Recommendation Report for Planning Permission for Works or Extension to a Dwelling

REF NO: Y/45/21/HH

LOCATION: The Chapel
Bilsham Lane
Bilsham
Yapton
BN18 0JX

PROPOSAL: Partial conversion of existing outbuilding to habitable accommodation (as ancillary accommodation main dwelling).

TYPICAL WINDOW DETAIL @ 1:20 SCALE

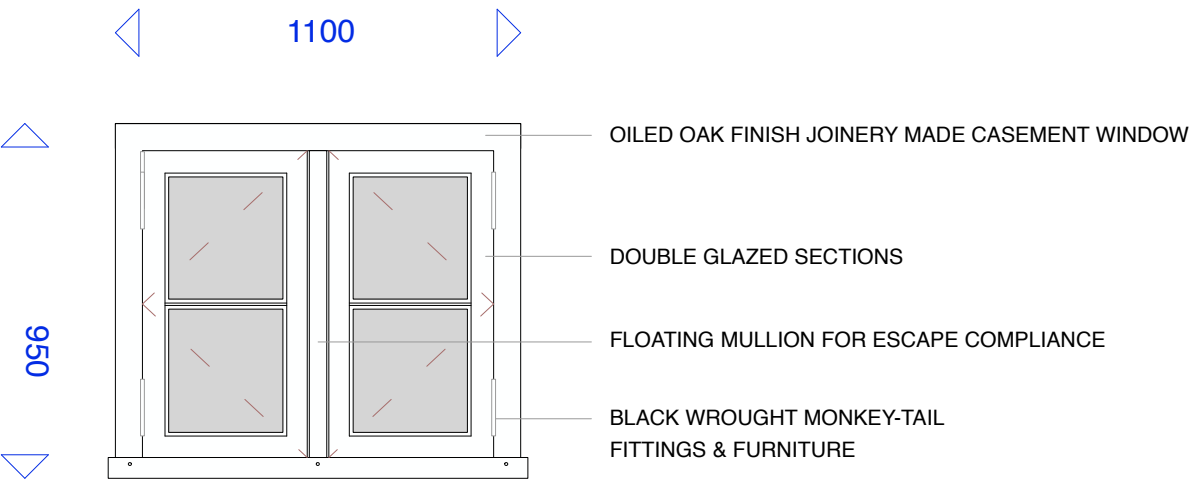
Conservation Officer: The proposal is for the partial conversion of the existing outbuilding to habitable accommodation. Externally, the alterations will consist of 2 timber windows to the existing front and rear gables, as well as the introduction of 4 conservation roof-lights (2 on the front pitch and 2 on the rear pitch). Internally, some small alterations are proposed which will enable a replacement staircase and an en-suite bathroom to be installed. The scale of the alterations and their impact is considered to be acceptable, and in keeping with the significance of the listed building, in its current residential use. It is recommended that any plumbing should not be visible from the south-west elevation of the main listed building. I note that details of the wooden windows have been provided, which appear to be acceptable.
